From: Jonathan Best <Jonathan.Best@arun.gov.uk>
Sent: 10 January 2025 15:56
To: Planning.Responses <Planning.Responses@arun.gov.uk>
Cc: Simon Davis <Simon.Davis@arun.gov.uk>
Subject: AL/137/24/RES

Land rear of Meadow Way including 24 Meadow Way Westergate.

I have reviewed this application with regards to ecology and Biodiversity Net Gain.

TREE PROTECTION PLAN (12083 TPP 01 Rev C)

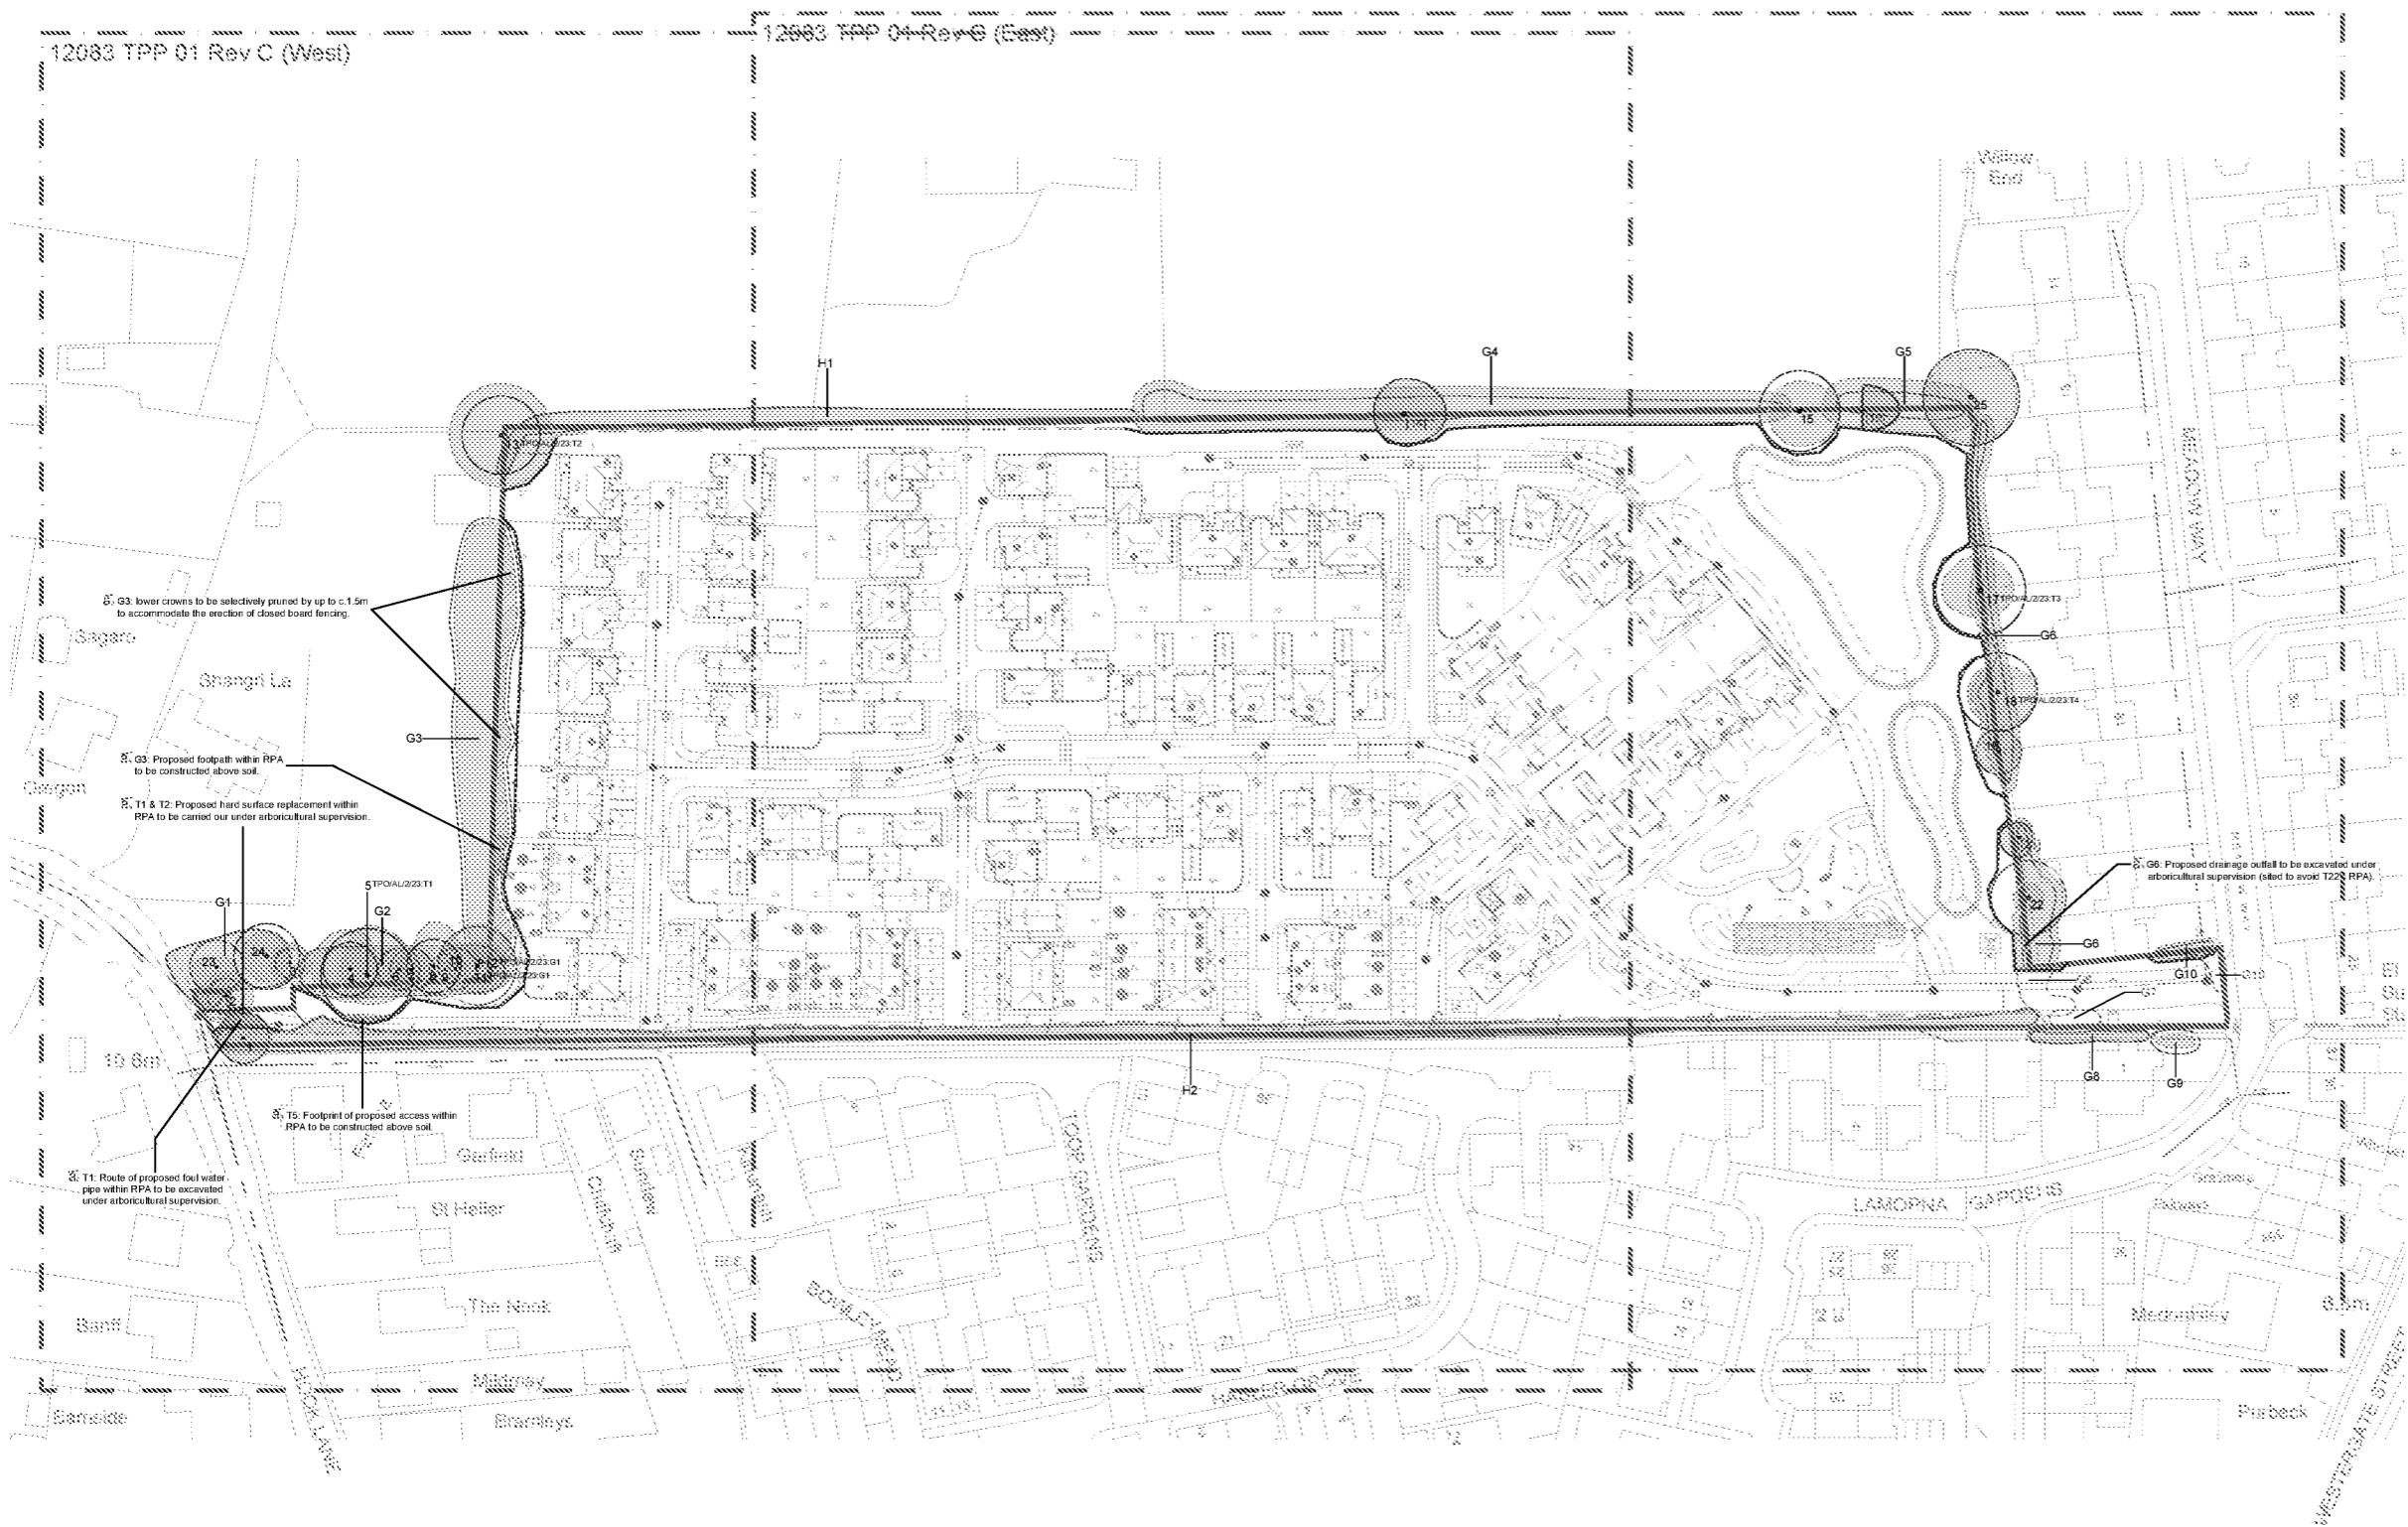
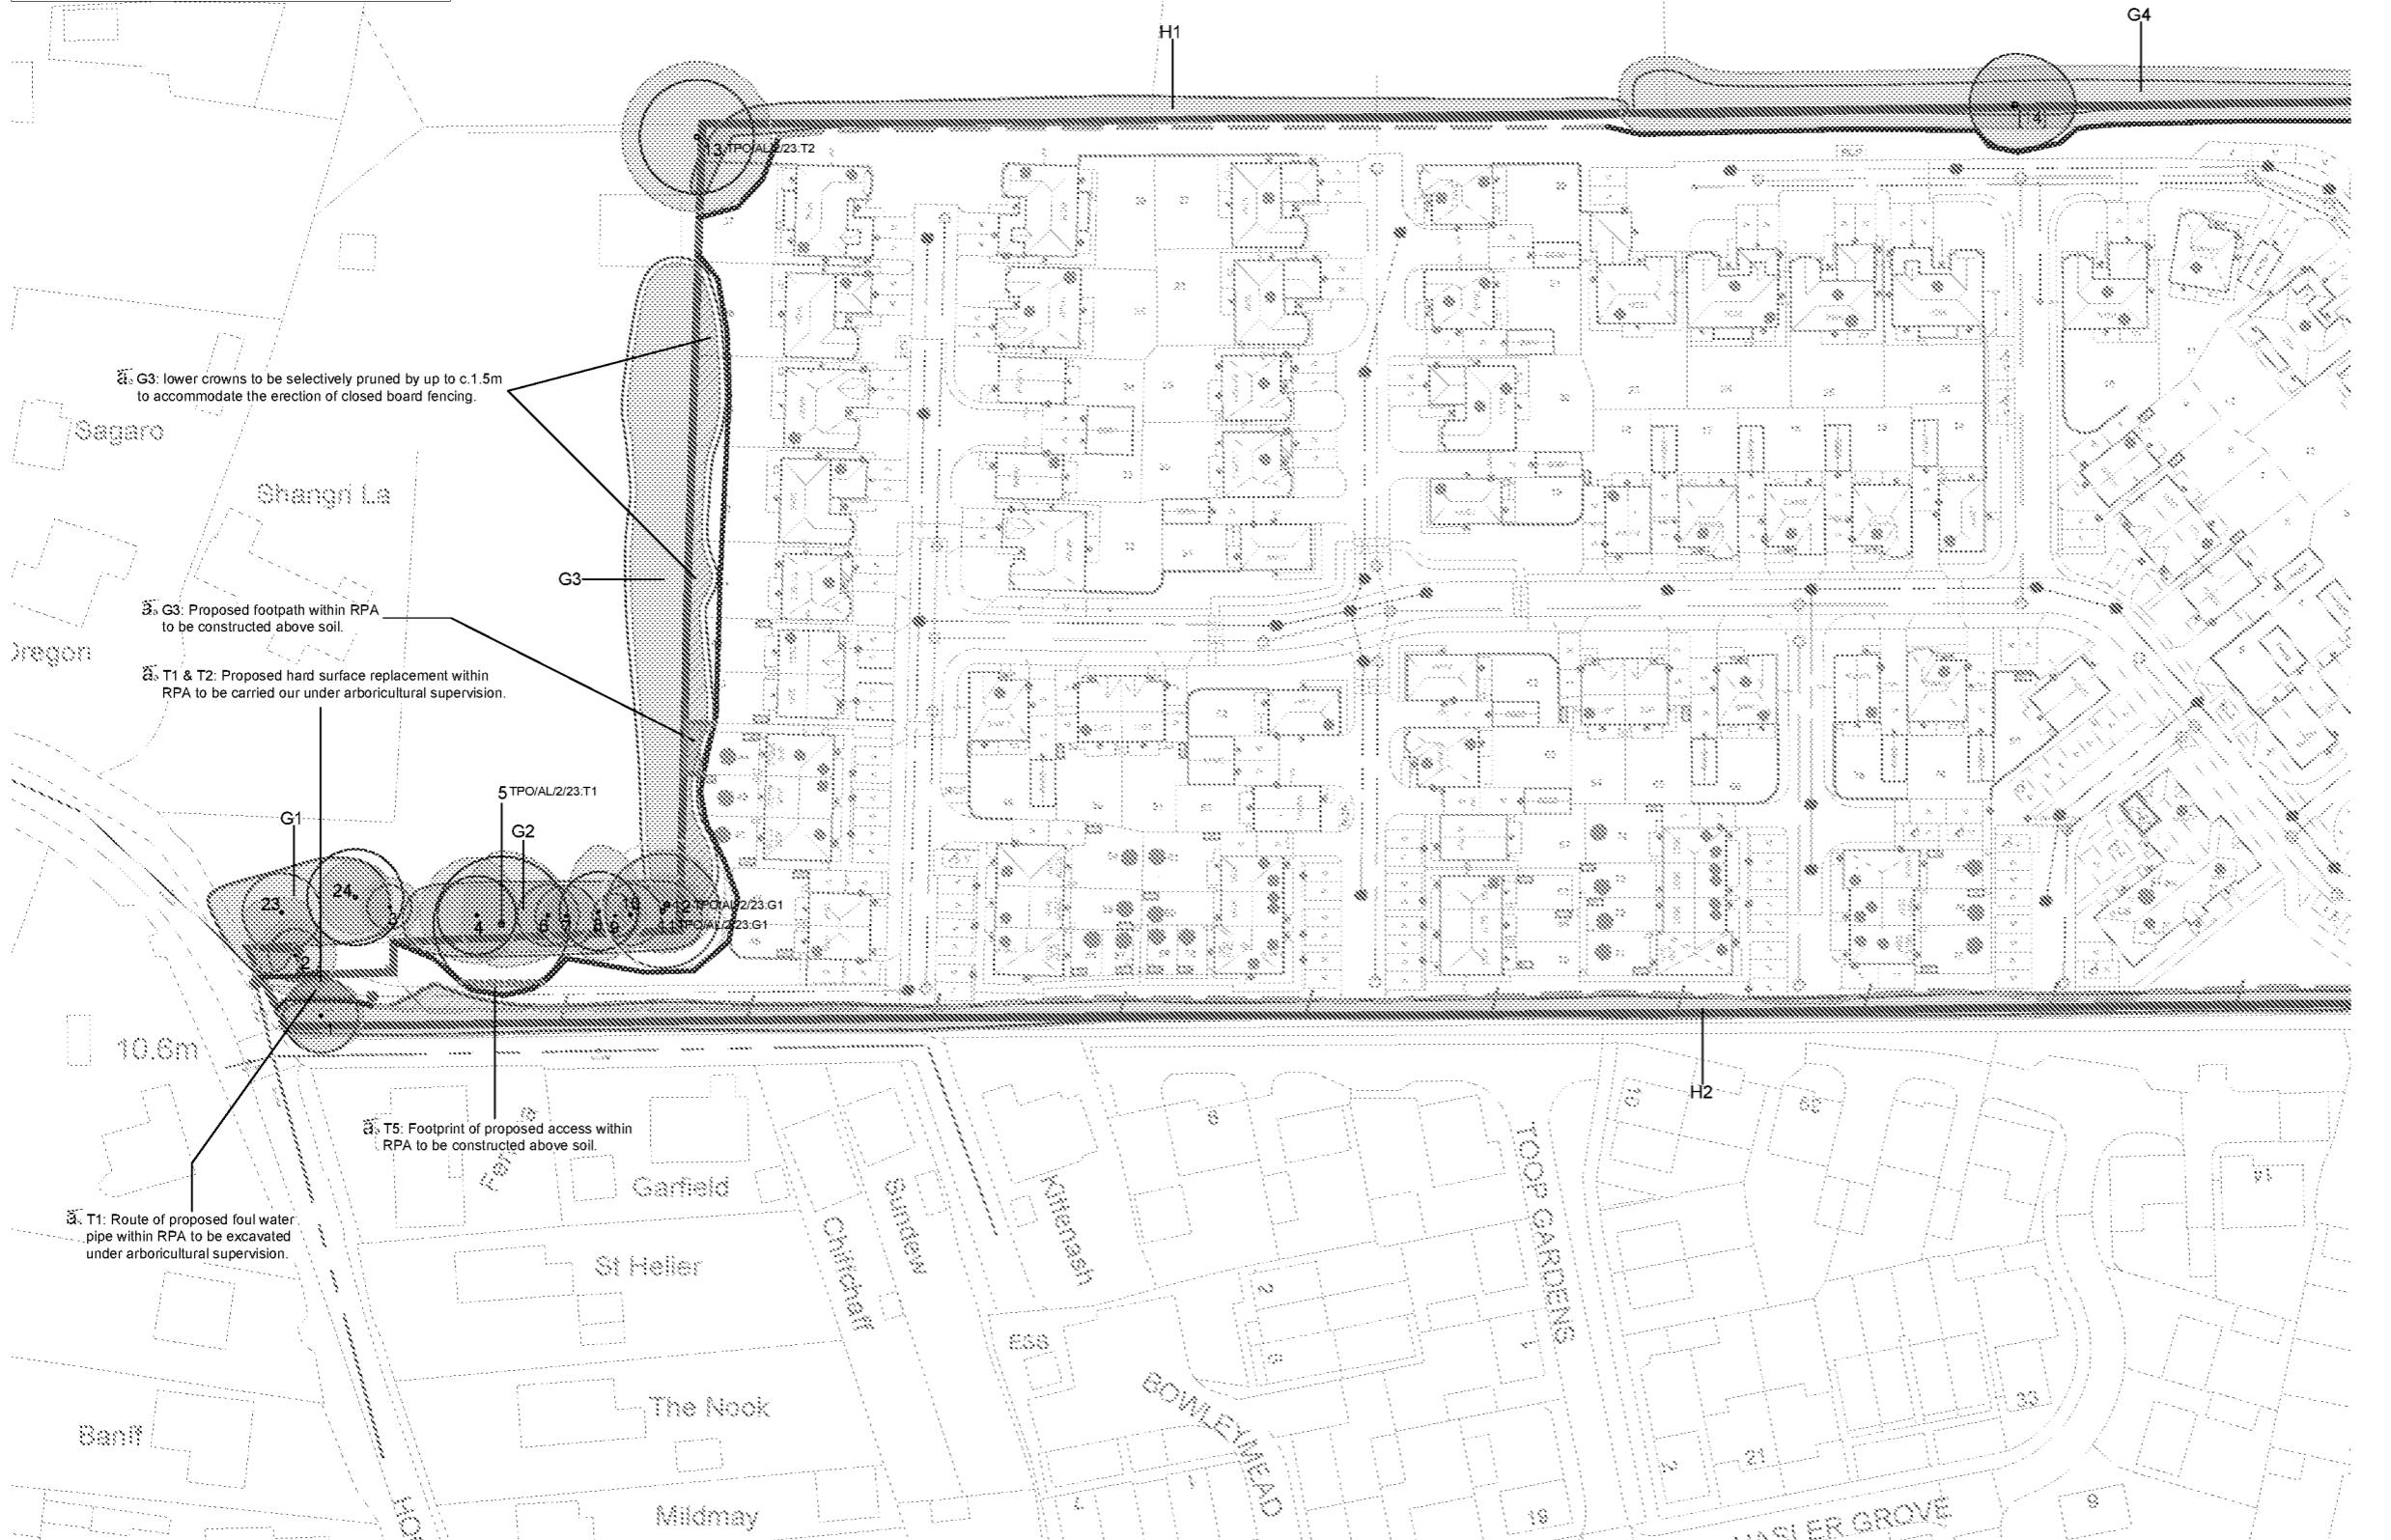
In addition to the RAMs, the retained boundary features should be protected by Heras fencing which would serve as a visual and physical barrier to protect these features from construction related encroachment and consequent accidental impacts during the construction stage.
